Mr Tom Harley  
Chief Executive Officer  
SYDNEY SWANS LIMITED  
PO Box 173  
Paddington NSW 2021  
16/12/2019

**Adaptive reuse of the Royal Hall of Industries (SSD-9726)  
Request for Additional Information**

RHI & SWIFTS BUILDING ELEVATIONS
EAST - WEST

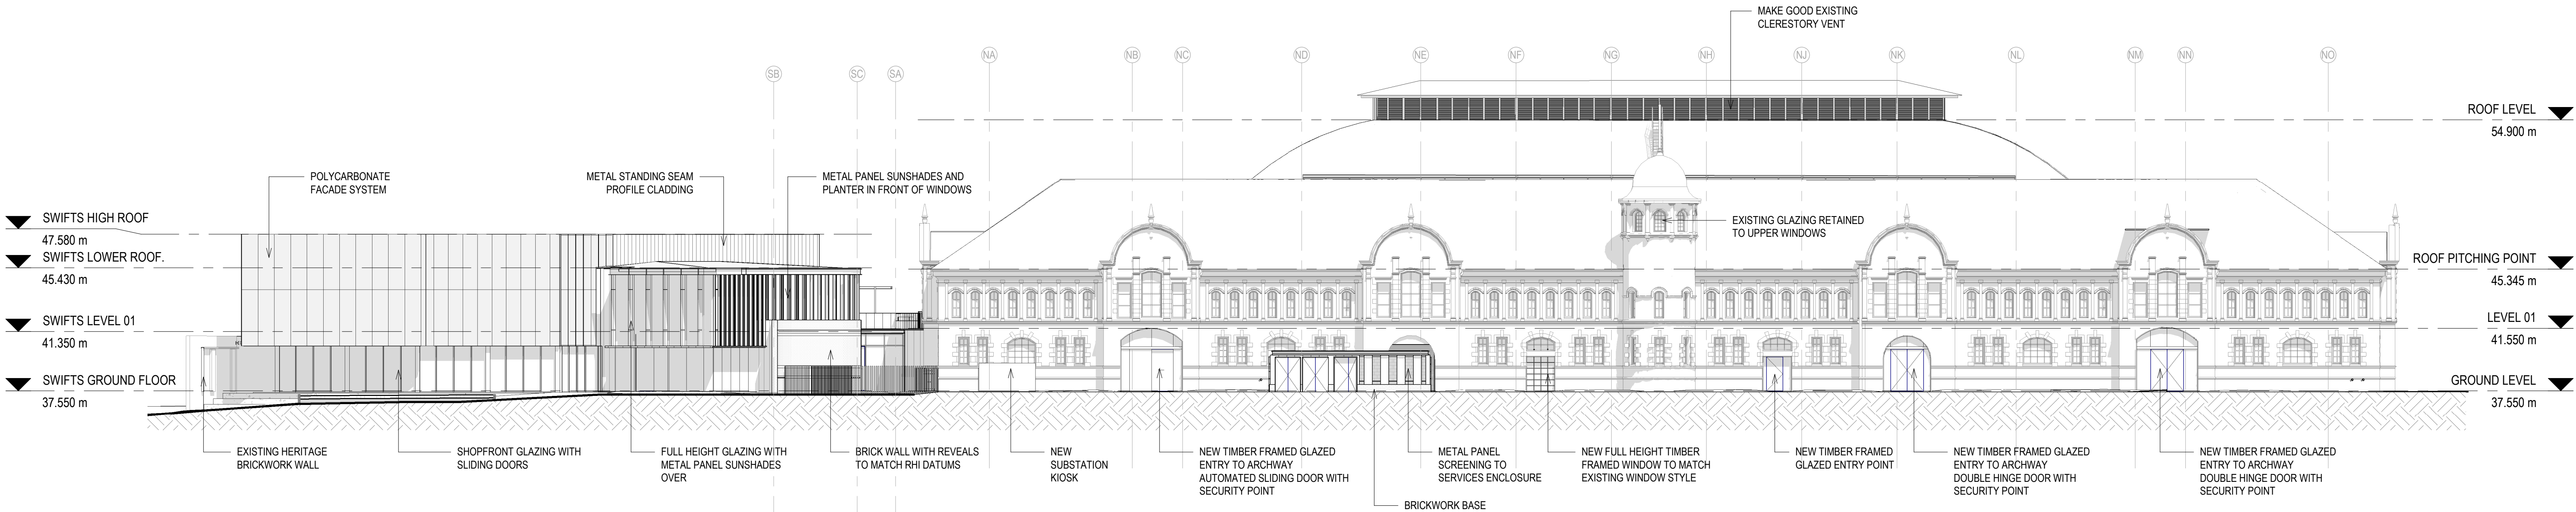
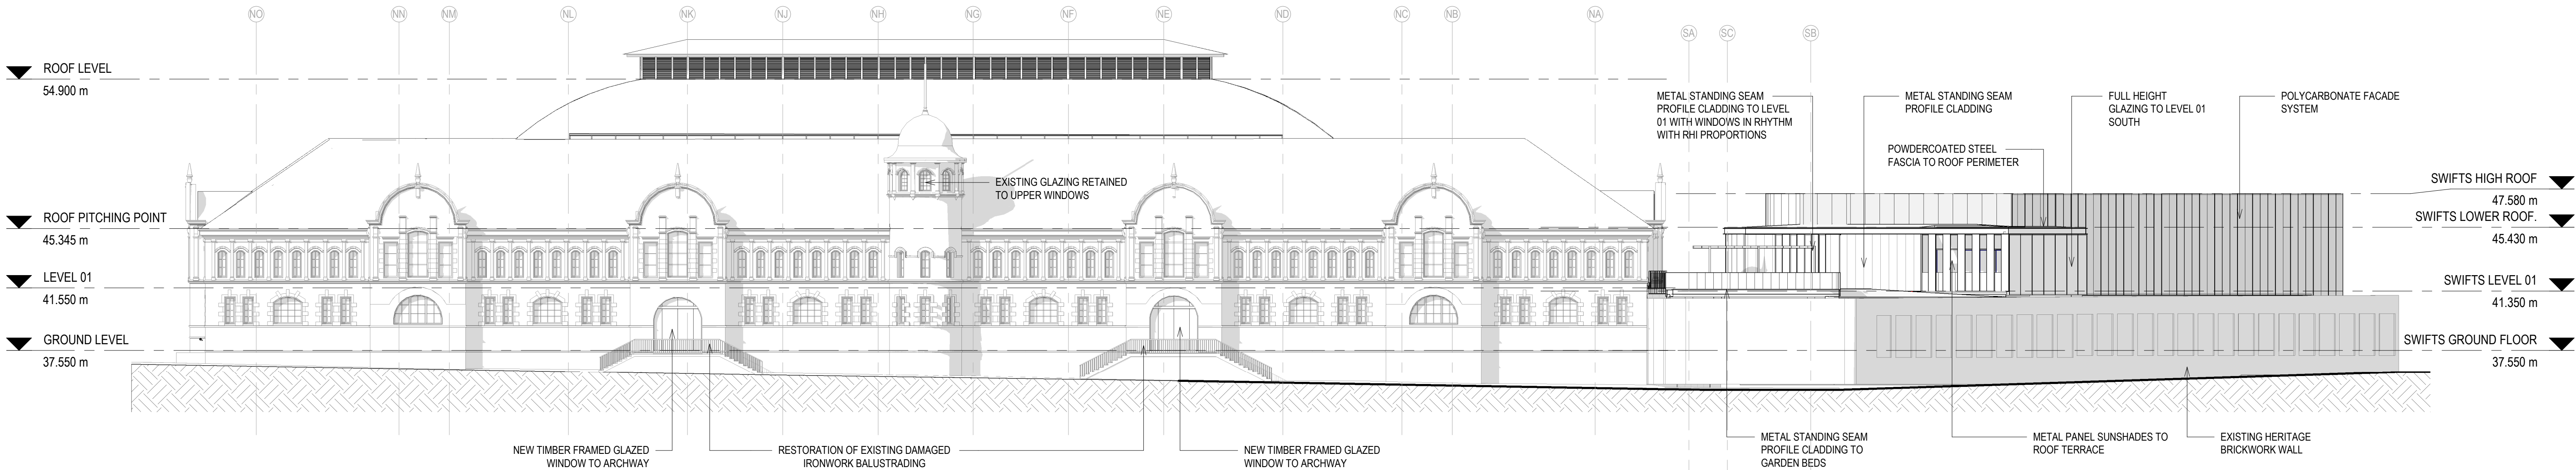
- Reconsider the approach to the first-floor façade of the Errol Fyn Boulevard elevation including options to increase vertical articulation.

1 GFA PLAN - GROUND LEVEL

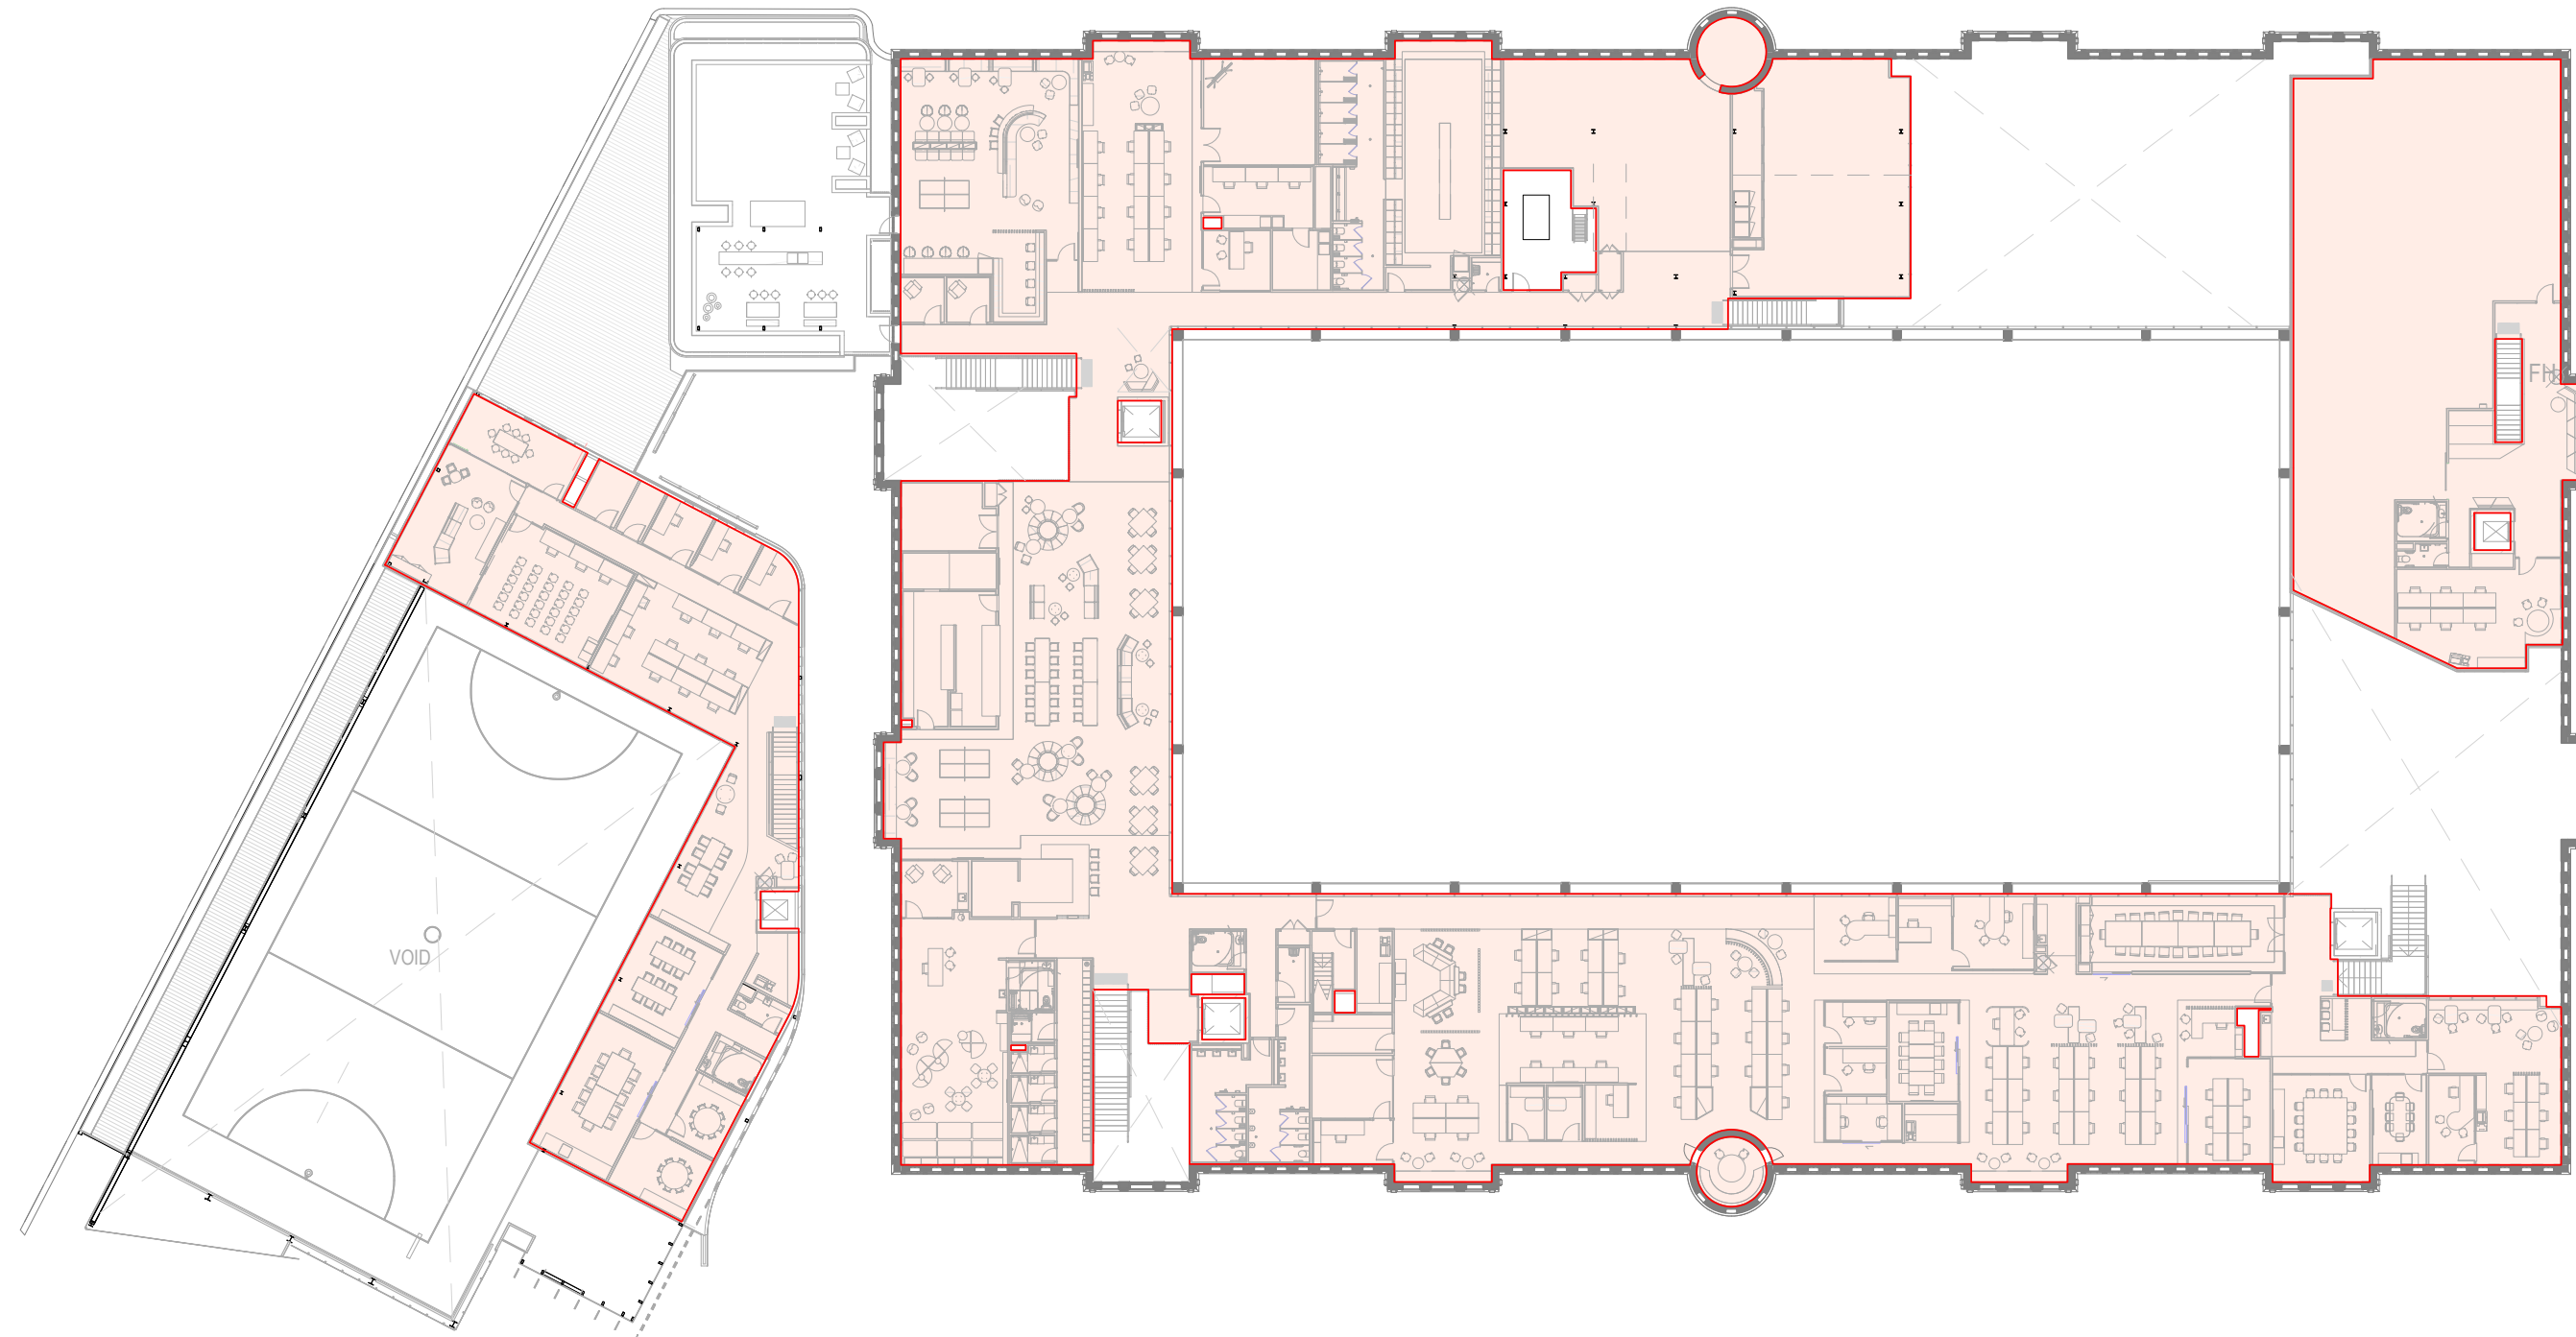
- Review the proposed GFA calculations and provide revised documents/plans as necessary, noting the GFA calculations provided within the RtS are not consistent with the revised architectural plans or the GFA summary (Appendix Aa).
- Provide a summary table which clearly cross references all proposed uses within the development to the appropriate land use definitions within the Standard Instrument (and SEPP 47 and ISEPP as appropriate) and provide corresponding GFA calculations.

2.3 DESIGN MASTERPLAN

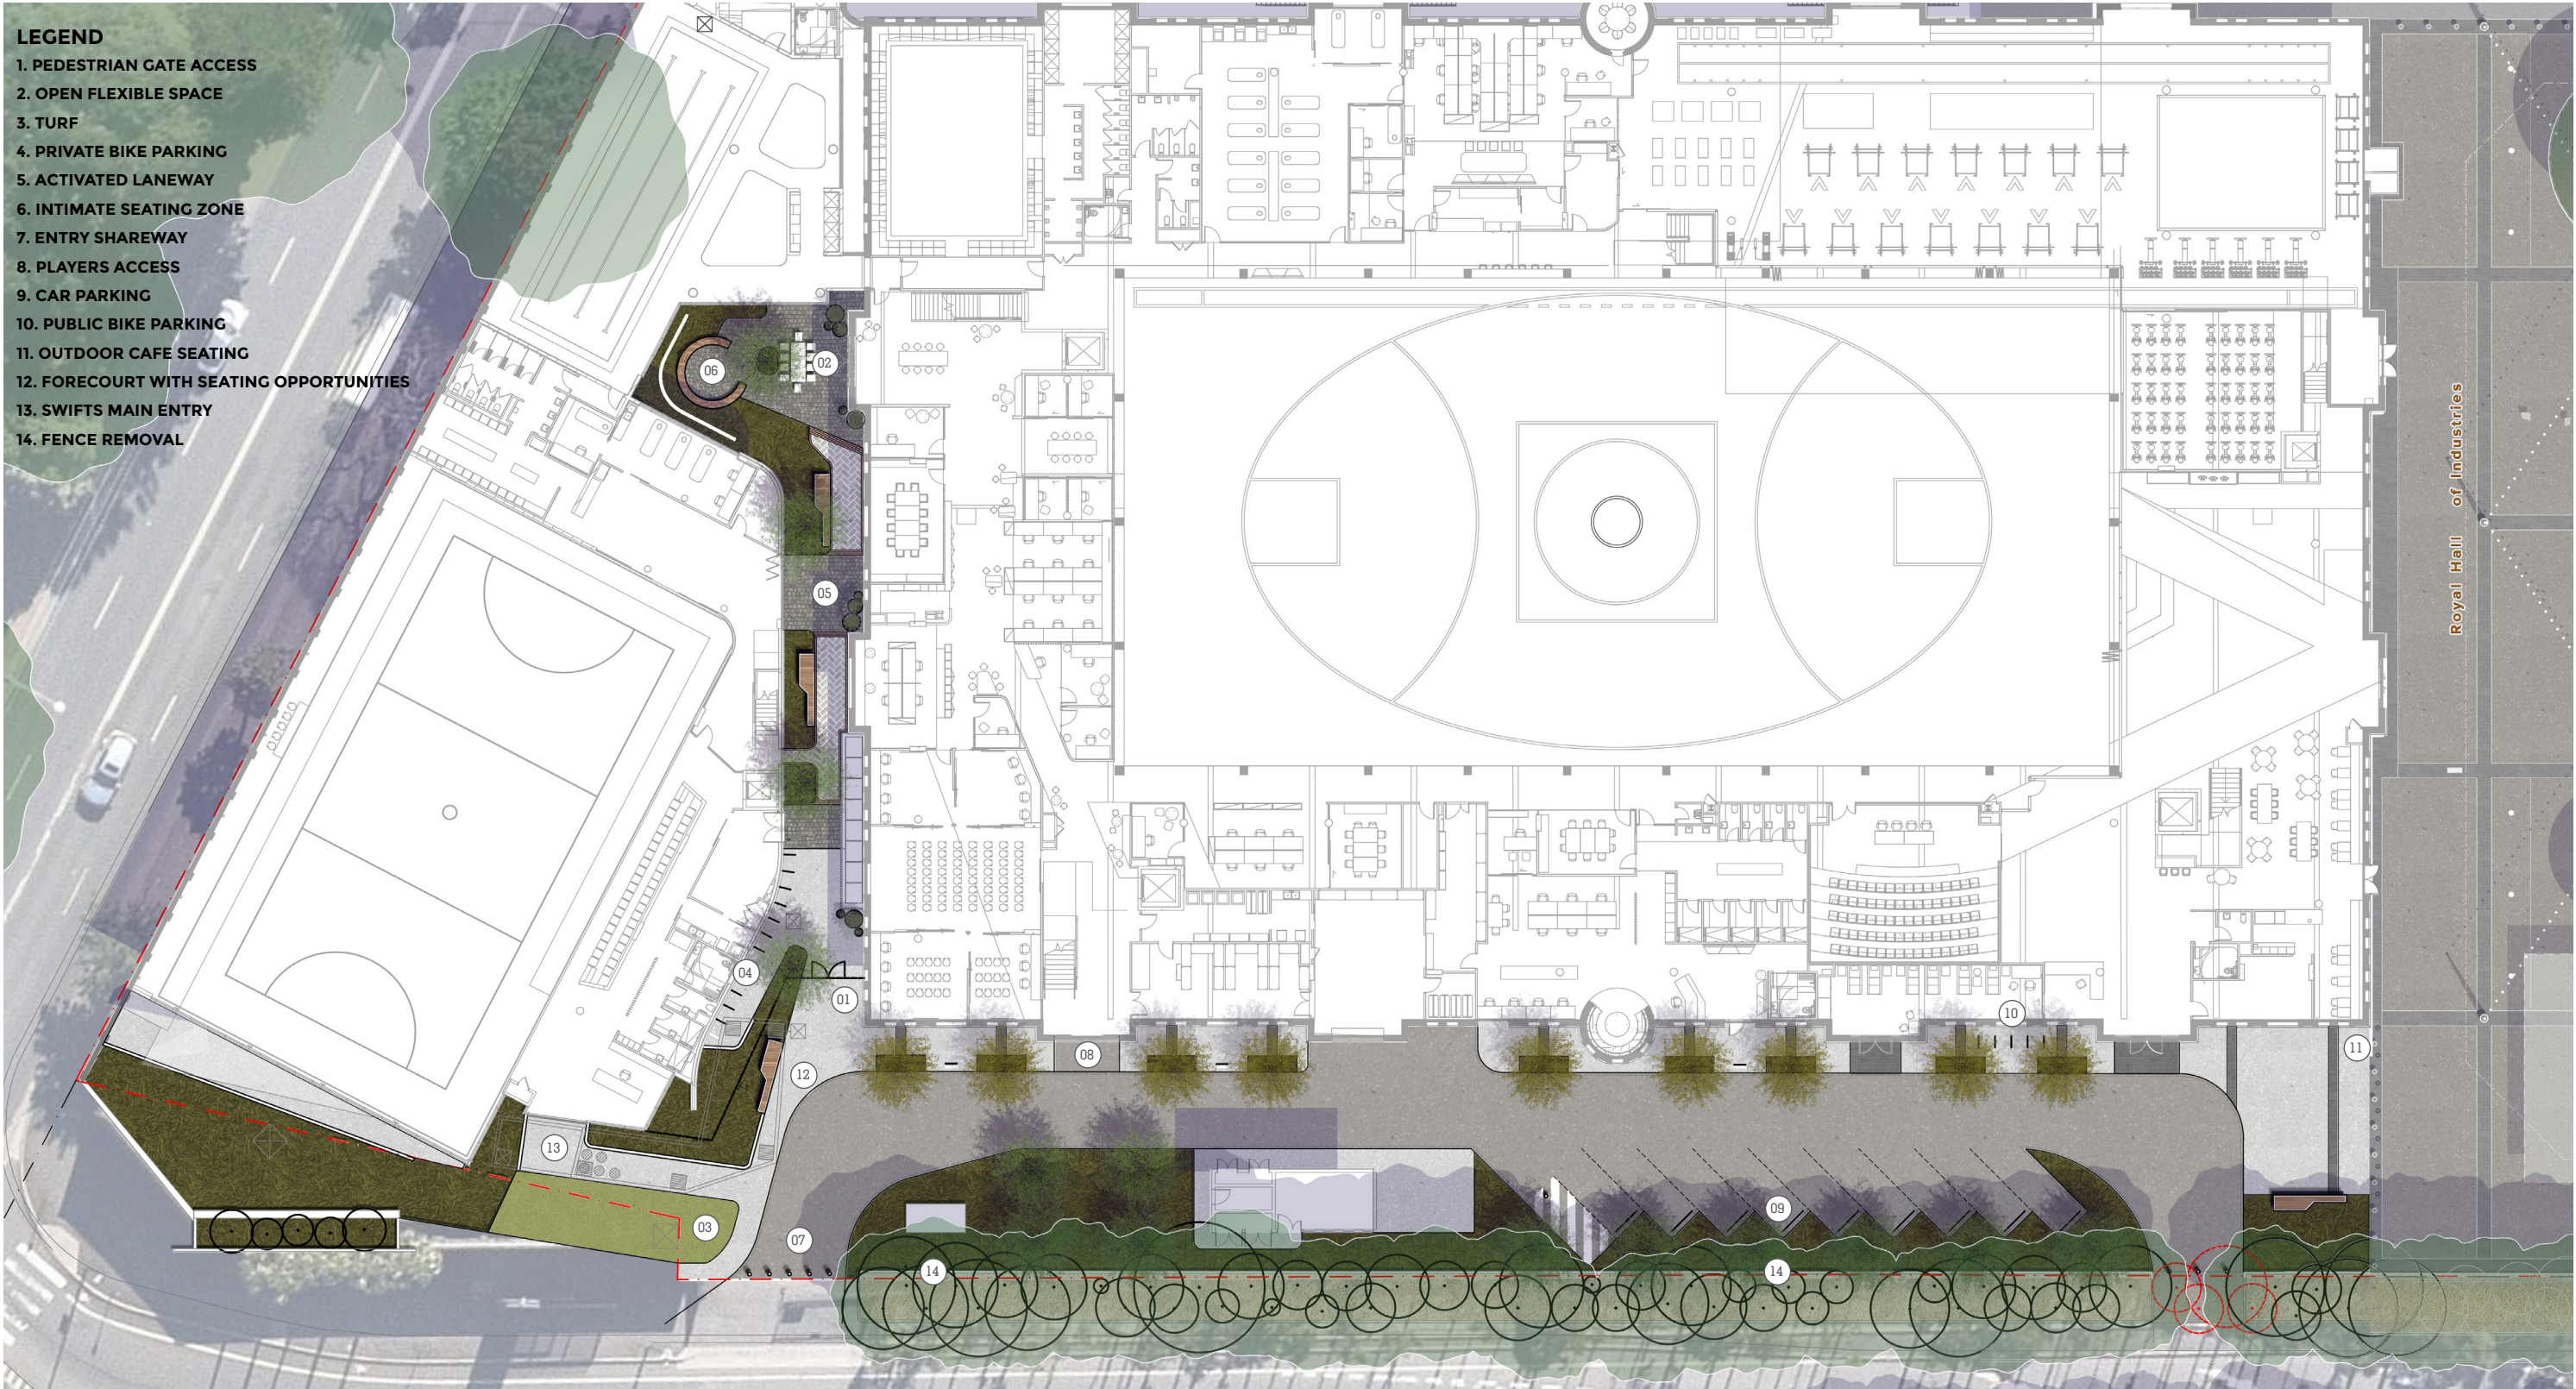
- Please update the landscape masterplan (including hard landscaping detail) to reflect the revised landscaping layout.
